**From:** [Murray, Jamie C \(BPA\) - TERR-KALISPELL](#)  
**To:** [Zach Torrance-Smith](#)  
**Subject:** RE: AU-26-00002 Engle - Notice of Application  
**Date:** Friday, February 27, 2026 8:49:24 AM

CDS is requesting comments on the following Accessory Dwelling Unit application: AU-26-00002 Engle.

**TO:** All Staff  
**FROM:** Public Works Plan Review Team  
**DATE:** March 16, 2026  
**SUBJECT:** AU-26-00002 Engle

SITE PLAN

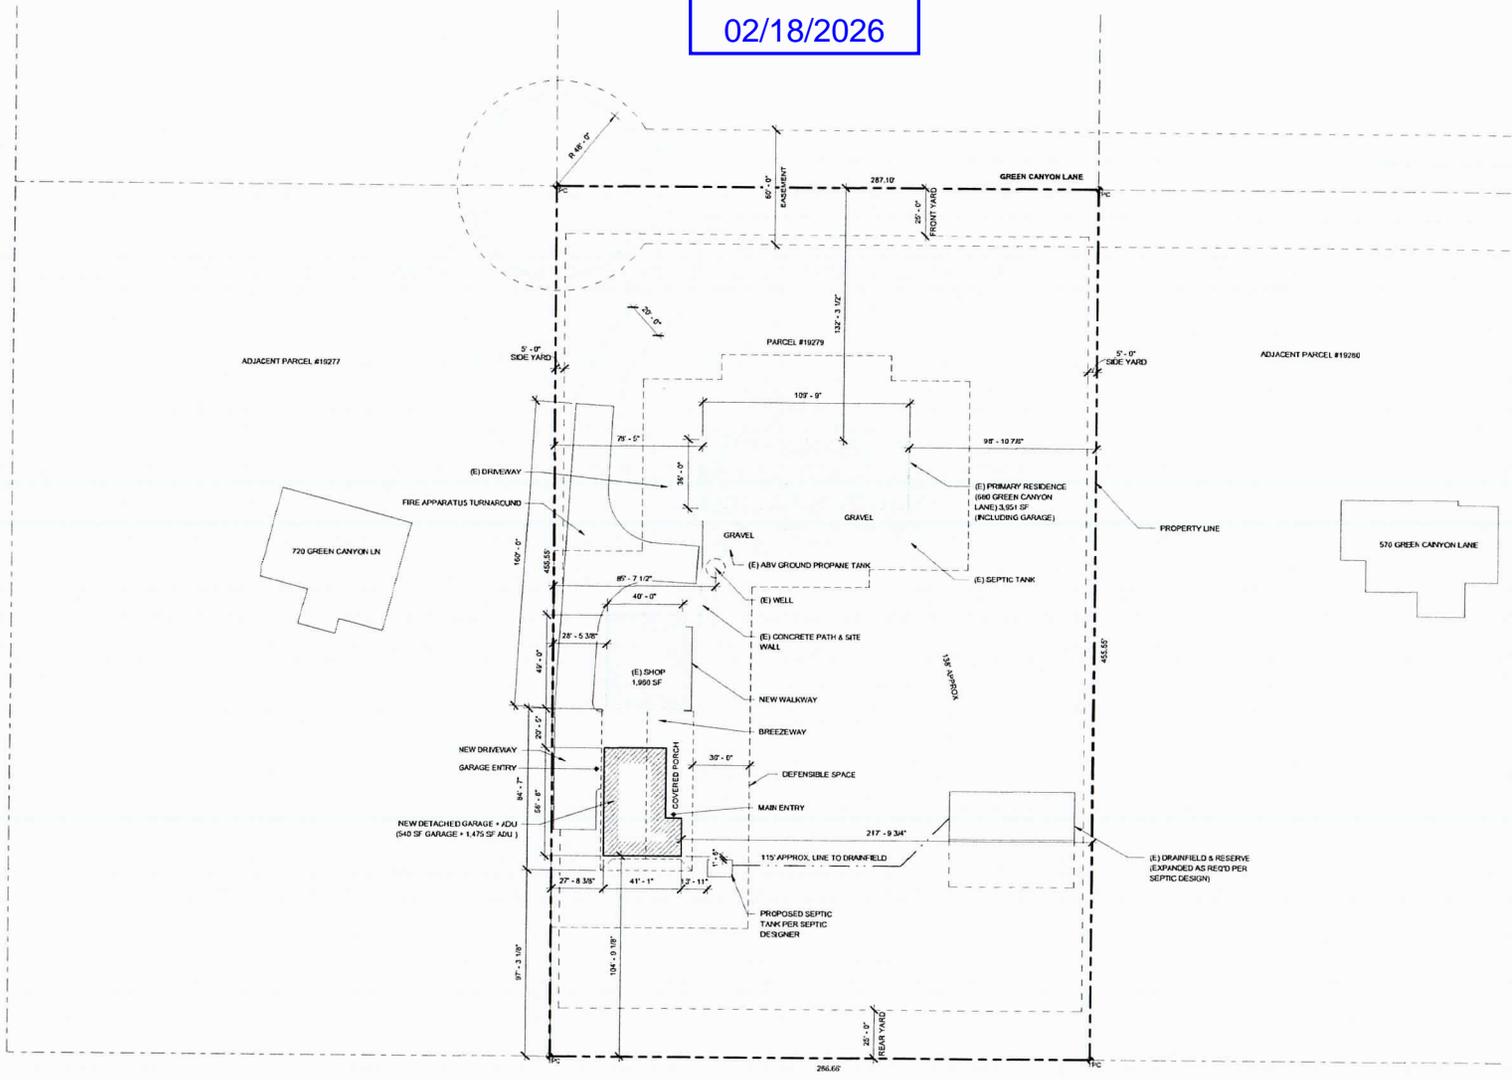
<b>ACCESS</b>	<ol style="list-style-type: none"> <li>1. An approved access permit shall be required from the Kittitas County Department of Public Works prior to creating any new driveway access or altering an existing access.</li> <li>2. Main home and ADU have one shared driveway to ADU and must meet 2024 Kittitas County Code Title 12 requirements for fire, life, and safety.</li> <li>3. Maintenance of driveway approaches shall be the responsibility of the owner whose property they serve. The County will not maintain accesses.</li> <li>4. Any further subdivision or lots to be served by proposed access may result in further access requirements. See Kittitas County Road Standards.</li> <li>5. Green Canyon Ln. is a certified Private Road.</li> </ol> <p>In addition to the above-mentioned conditions, all applicable Kittitas County Road Standards apply to this proposal. Access is not guaranteed to any existing or created parcel on this application.(RC)</p>
